Application Ref:	3/2016/0740	 Ribble Valley Borough Council www.ribblevalley.gov.uk
Date Inspected:	23 September 2016	
Officer:	AD	
DELEGATED ITEM FILE REPORT:		REFUSAL

Development Description:	Application for retention of unauthorised alterations.
Site Address/Location:	Primrose Cottage 4 Main Street Bolton by Bowland BB7 4NW

Proposed First Floor

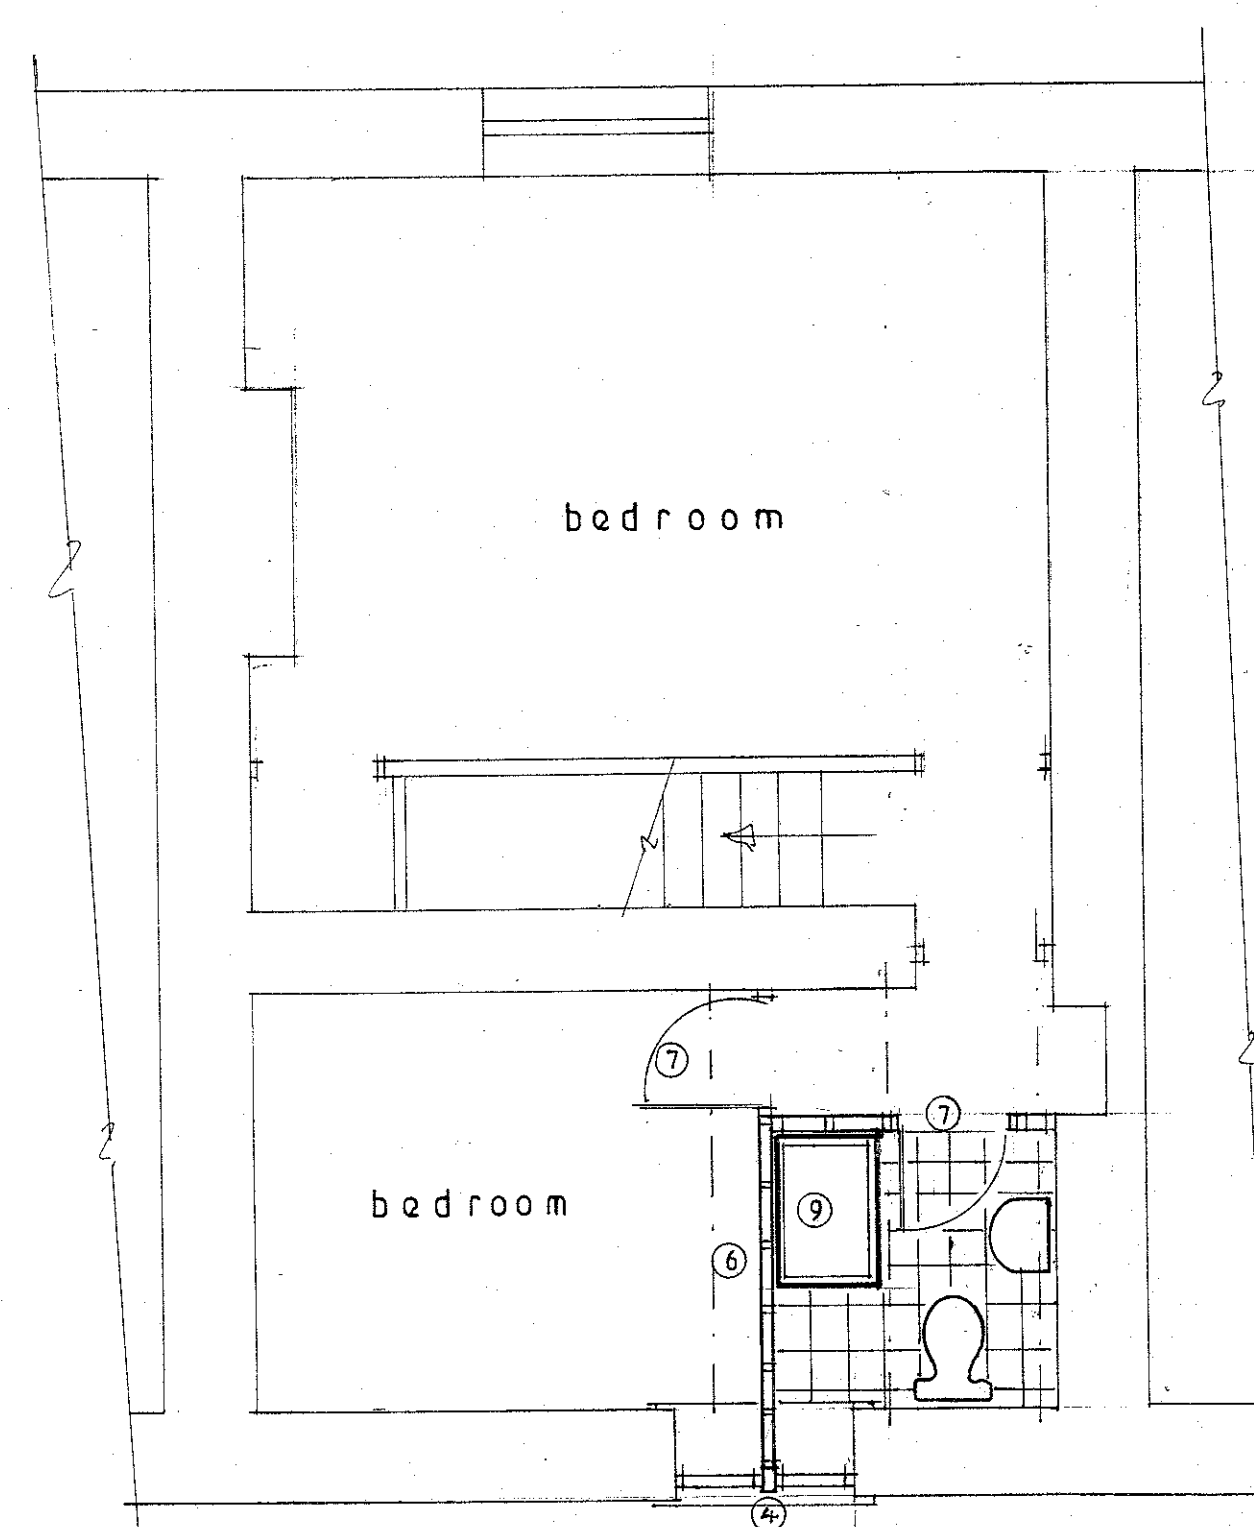
- (iii) Subdivision of first floor room and replacement window with incongruous and visually conspicuous timber mullion – the external fabric (window jambs) indicates that two first floor openings (one at No.6 Main Street) may be original openings. This suggests the recent division of the room and bisecting of the window to be unsympathetic to the special interest. No other window in the listed building or terrace is of this form and it is conspicuous. The impact of the installation of services (floor boards are of the wide and early type) cannot be ascertained from submitted information.

Proposed Rear Elevation

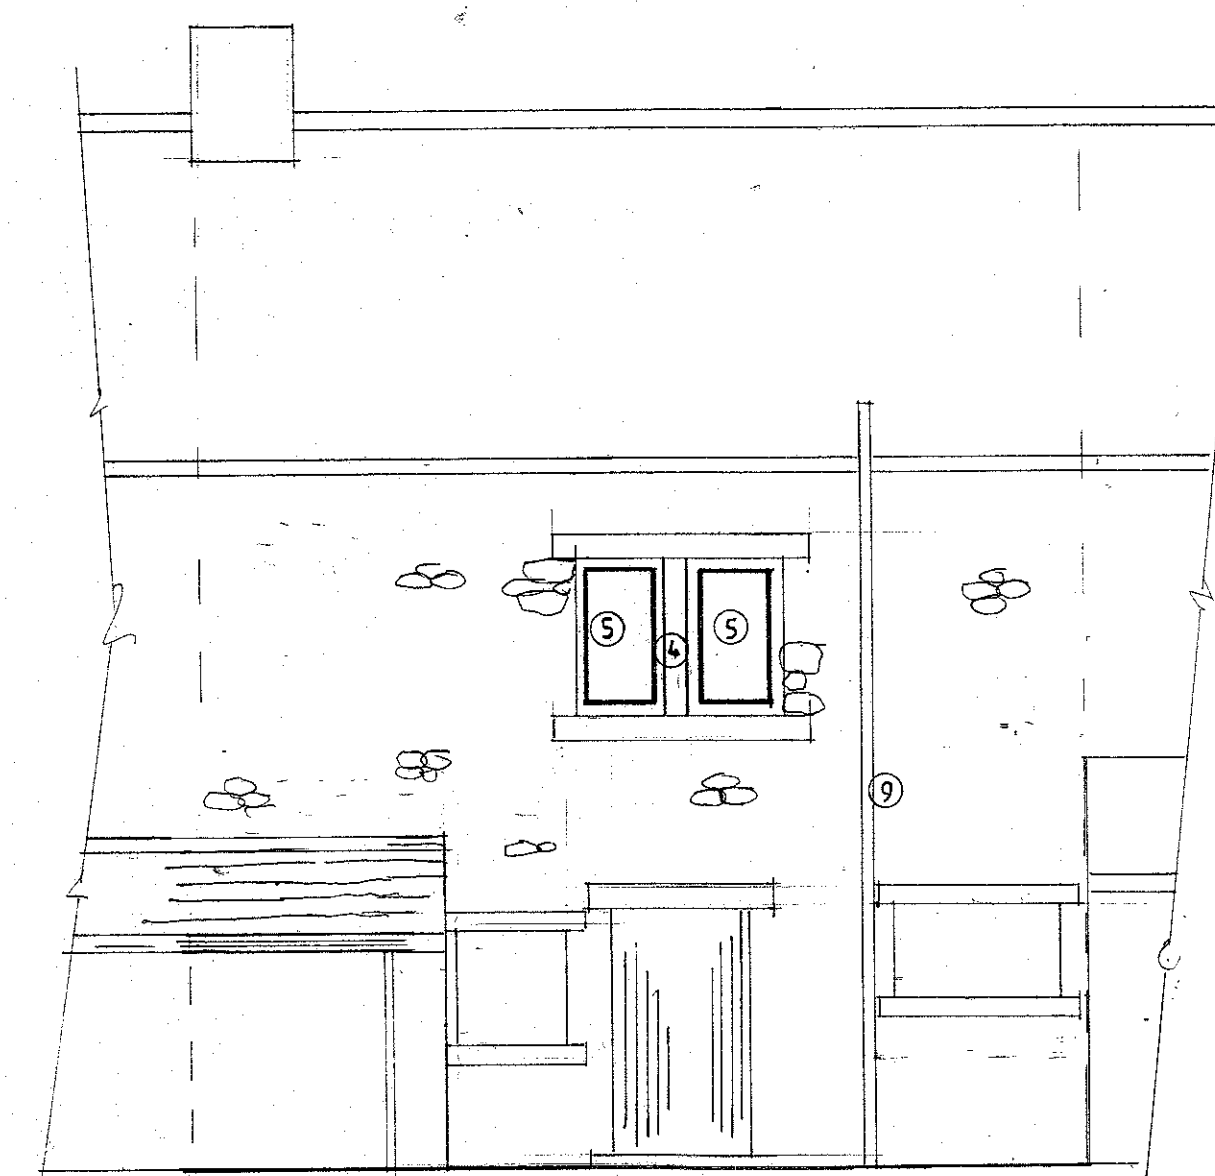
In the absence of a comprehensive Heritage Statement, consideration has been made to photographs taken by the case officer at previous inspections. In addition to the works associated with relocation of the bathroom from ground to first floor, the rear door has been removed and replaced with a different style.

architectural and historic interest of the listed building, the setting of adjoining listed buildings and the character and appearance of Bolton by Bowland Conservation Area because of the loss of important historic fabric and plan form and the installation of an incongruous and visually conspicuous first floor window frame.
--	--

Proposed Ground Floor

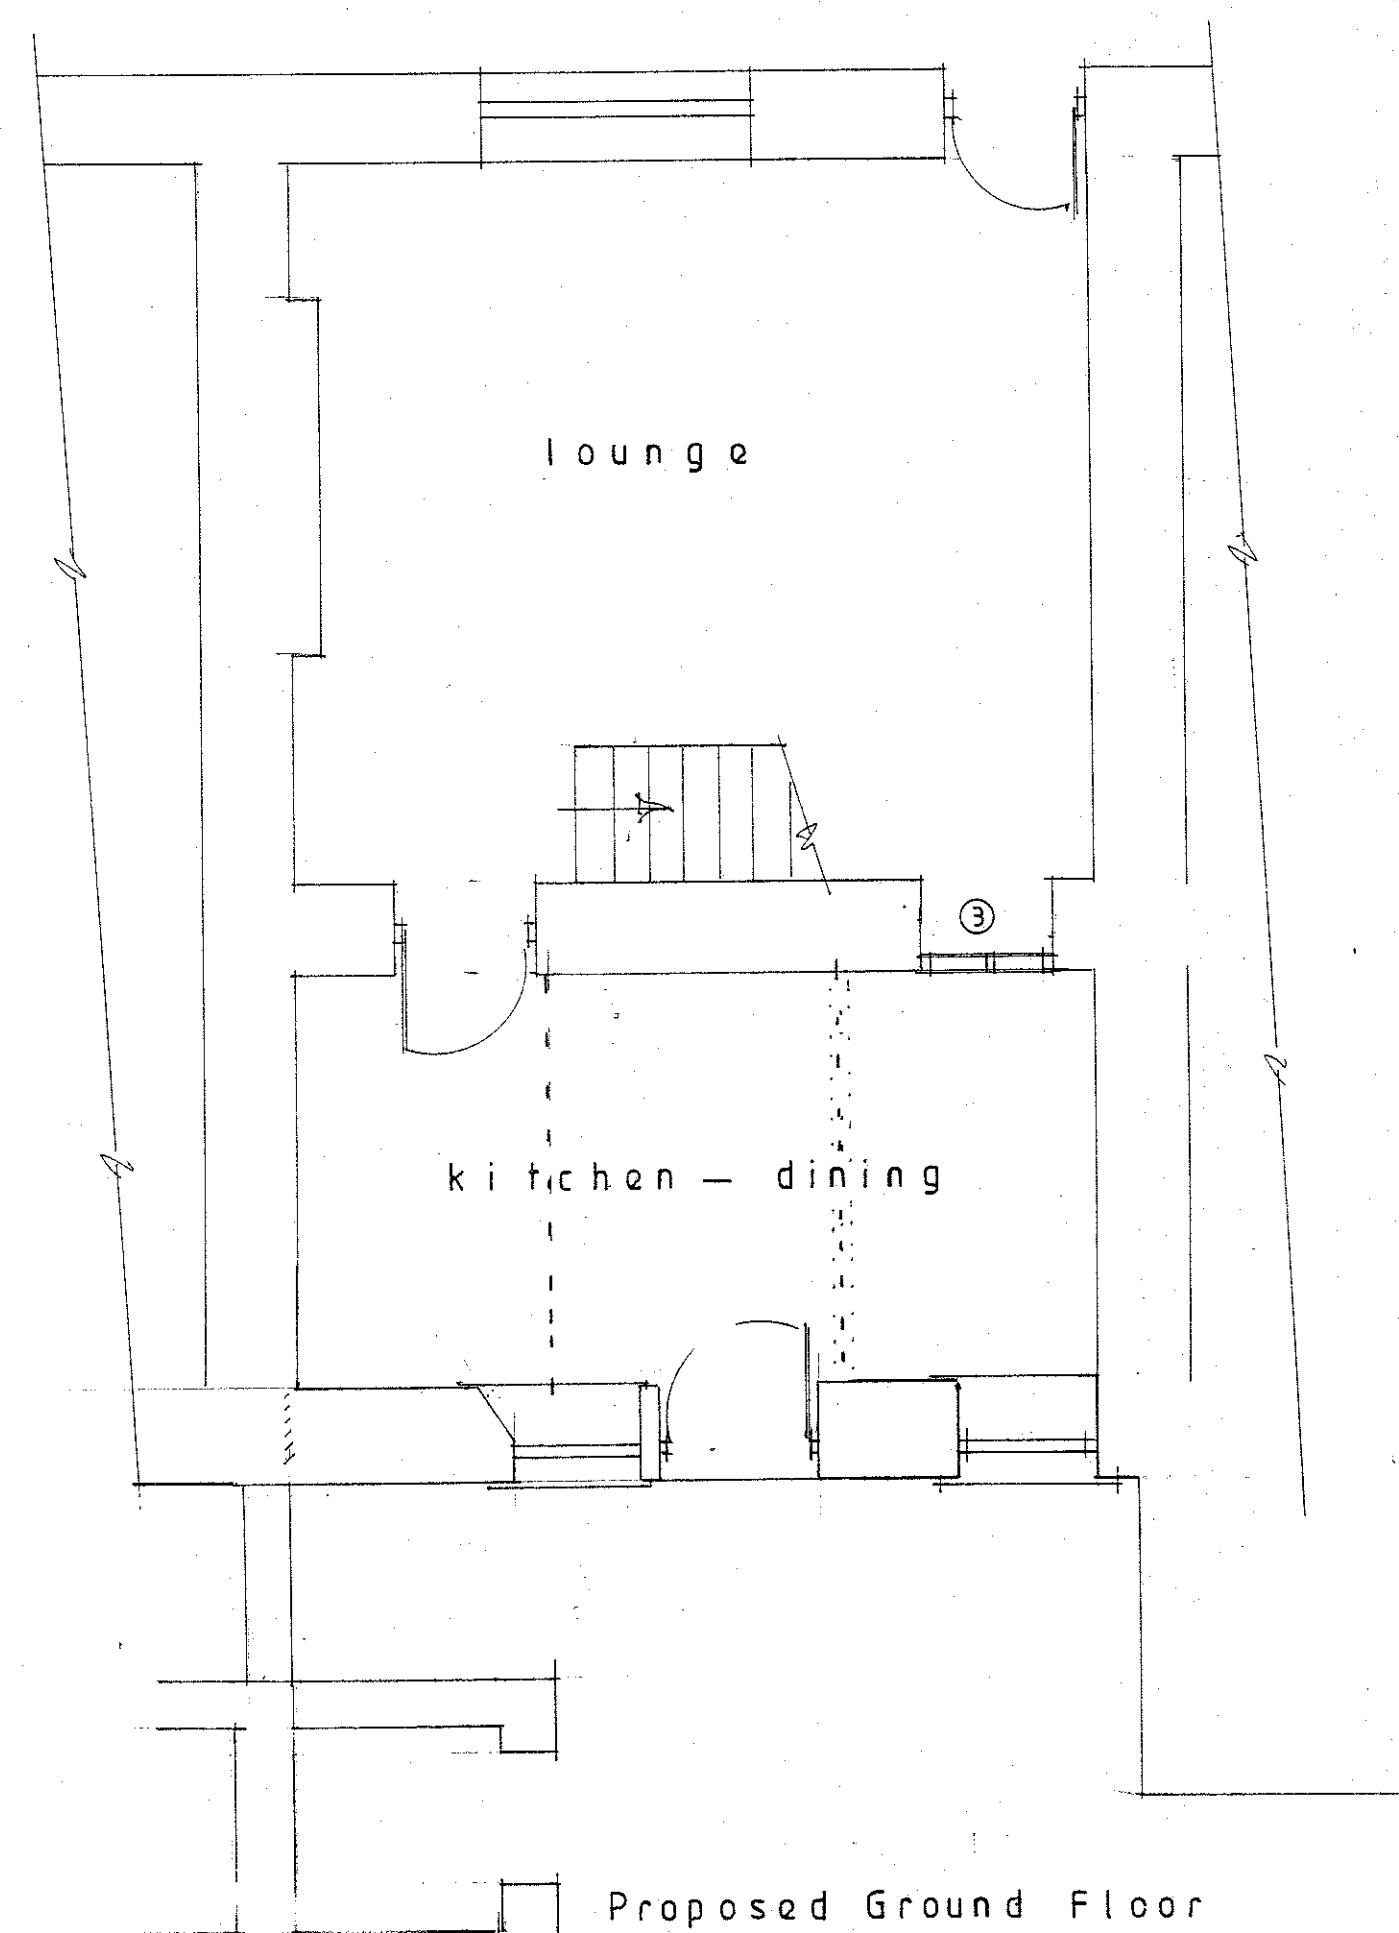
- (i) Loss of door;
- (ii) Removal of ground floor wall – no convincing evidence has been submitted to confirm that this was a concrete block wall. The location of two historic doorways from the hall/lounge into what appears to be a later outshut addition (see depth of intervening wall) may suggest that the ground floor of the outshut has always been divided;
